Robert & Sandra Keough
"Tryagain"
1117 Spring Mountain Road
SWAN VALE NSW 2370

Submission Major Project - White Rock Wind Farm – MP 10_0160

Figure 2-1 Proposed site location in relation to other proposed wind farms

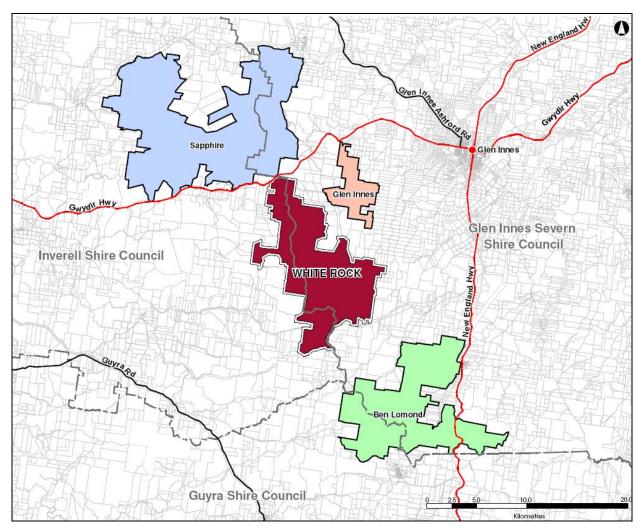
Combine this project with the other three (3) wind farms there is a considerable area that will no longer have aerial agricultural services in our region. *Refer Figure 2-1, Section 2, 2.1*

Figure 9-8 Predicted noise levels for the REpower MM92

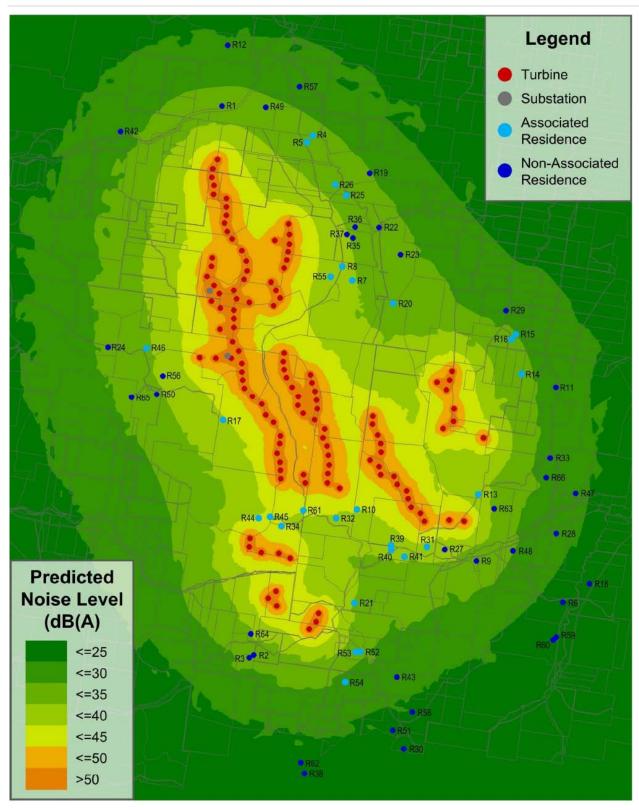
Please note location errors within the EA: Our property number R56 (Tryagain) is **not** positioned on the correct property in the following areas,

- Page 110 & 111 - Section 9, 9.2.3, Figures 9-8 predicted Noise Levels for the REpower MM92 & Figure 9-9 Predicted Noise Levels for the Vestas V90
- Appendix G -Noise Contours Page 47 & 48 -Environmental Noise Assessment (being same maps as above)

Refer Figure 7-1, Community Consultation map, Section 7, 7.2.2.2, page 80 for the correct location of the house for property number R56(Try Again).

Please note as previously stated that property number R56 (Tryagain) is not positioned correctly on the maps on pages 47 & 48 of the Noise Assessment. R56 is not shown on the correct property but further away.

Figure 10-2 Landing strips within 5km of a turbine

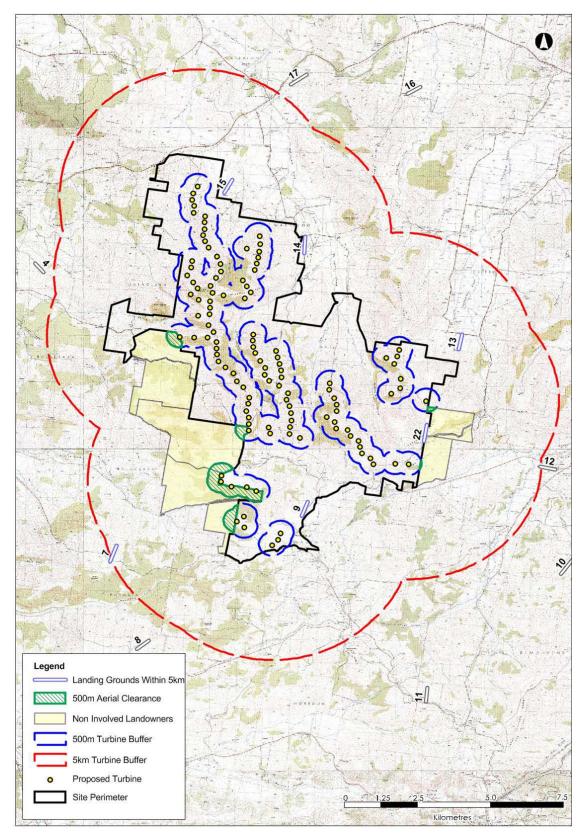
Refer Page 138 EA, Figure 10-2, Landing strips within 5km of turbine

500m Aerial Clearance has been shown on our property due to a cluster of towers being situated on the north-east boundary. This will disadvantage the property for any aerial applications. (Towers: 32 & 33). The local Aerial Spraying contractor has indicate a 1km "No Go Zone".
